Address: Brooklands, 17 Northfield Lane Huddersfield HD8 0QT

Application number: 2024/92324	
What is the application for?:	Formation of basement to increase living accommodation
Address of the site or building:	21, Northfield Lane, Highburton, Huddersfield, HD8 0QT
Postcode:	HD8 0QT

SOUTH WEST ELEVATION

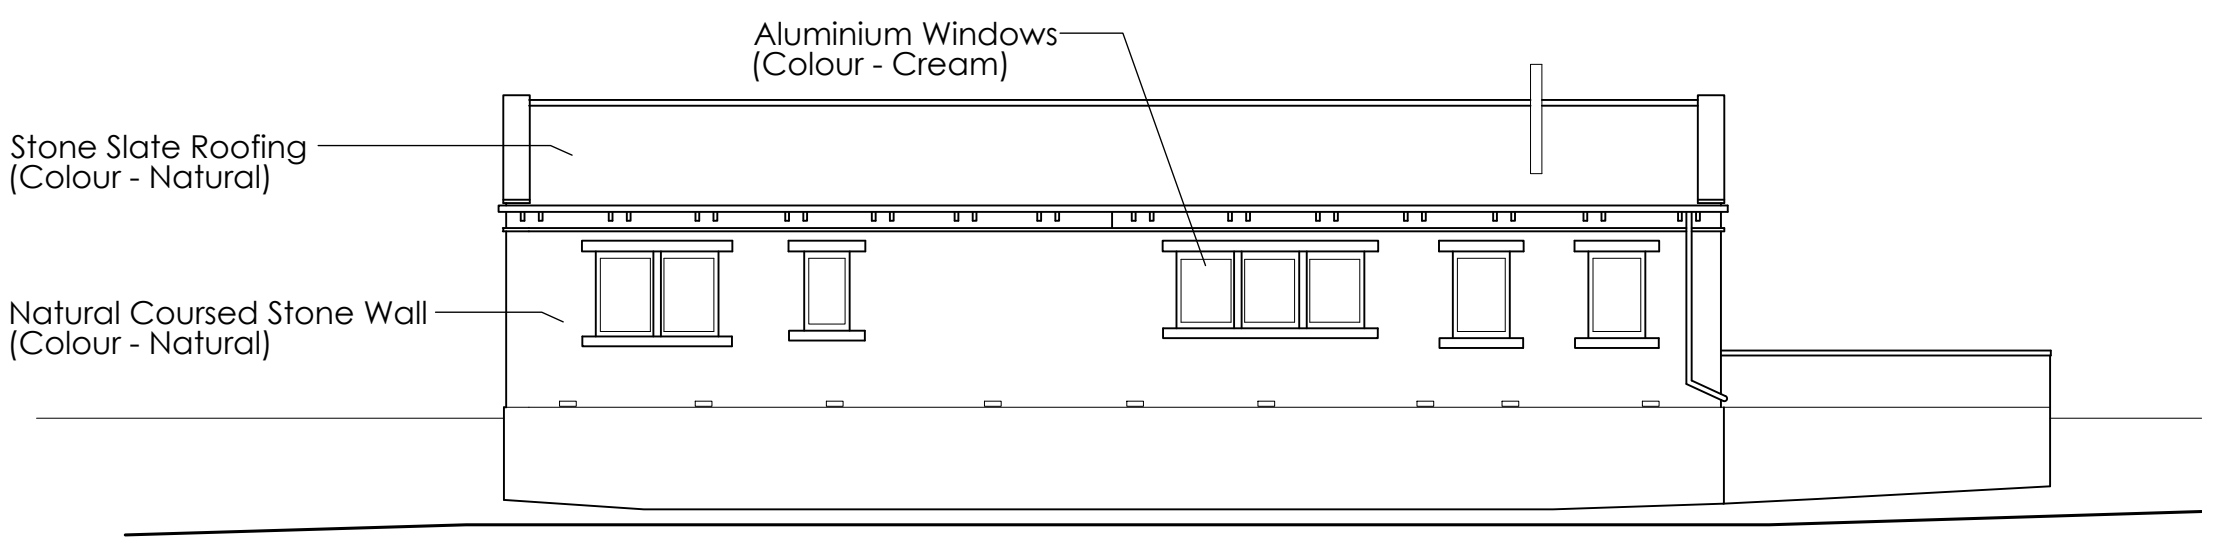
Enforcement. The current application 2024/90824 (to install windows) below the ground floor include two south/ south west elevation drawings. The first one, (drawing 3140 (PL) 05) is detailed as the APPROVED drawing and is as detailed in the original application 2017/90828. However, the second drawing (drawing AL 0020), detailed 'as proposed' shows the depth below the property ground floor level to be substantially deeper than the 'approved drawing' and is detailed 'AS EXISTING'.

It is therefore clear and incontrovertible that the existing elevation is not as approved; furthermore, if the building had been built as the approved drawings there would be insufficient height to install any additional windows as proposed on this elevation. The above is extremely relevant as this site has been the subject of numerous applications over recent years and in considering the current application 2024/90824, I would encourage the planning authority to look at one of the original proposals (2008/93679), this sets out the original concept for this annexe, i.e., to have a lower ground floor. This application shows on drawing number 2619 (0) 04 (the north and west elevations) that this could only be achieved by substantial excavation to the outside field level, with the resultant increase in the overall height of the south elevation. It is not unreasonable to conclude that the increase in depth under this property following the construction has been carried out with the intention to create a basement level.

Notwithstanding the above, it is also noteworthy that on the current application the reason stated in applying for a variation is: For the introduction of 3no. additional windows to match existing to undercroft on south west elevation of annexe to provide natural light to this area. There is no undercroft detailed on the approved plans to which this variation refers, there should be nothing more than a floor void under the ground floor and consequently there would be no valid reason in having natural light. Therefore, the reason stated for the variation has no merit, why would there be any reasonable explanation for requiring natural light in a floor void? The south elevation which is clearly visible from Far Dene and the public footpath running through the fields adjacent to the property already has a single storey building with a stone elevation in excess of the approved drawings . To have windows put at the lower level would create an unacceptable change to the original buildings and give the impression of a two storey property which was only given approval on the basis that it didn't materially diverge from the visual effect of the original outbuildings. Lastly, the Appeal Decision on the original application (2017/90828) under paragraph 5 of the reasons stated - In part, the replacement building would replicate the dimensions of the stone garage and In the schedule of Conditions set out by the Inspector (item 2) The development hereby permitted shall be carried out in accordance with the approved plans 3096(LP)01 Rev A, 3140(PL)01, 3140(PL)02, 3140(PL)03, 3140(PL)04 and 3140(PL)05. It is clear from the above that neither of these conditions has been met and that the proposed alterations are only possible by failing to adhere to the plans as presented to Kirklees Council and the Planning Inspectorate
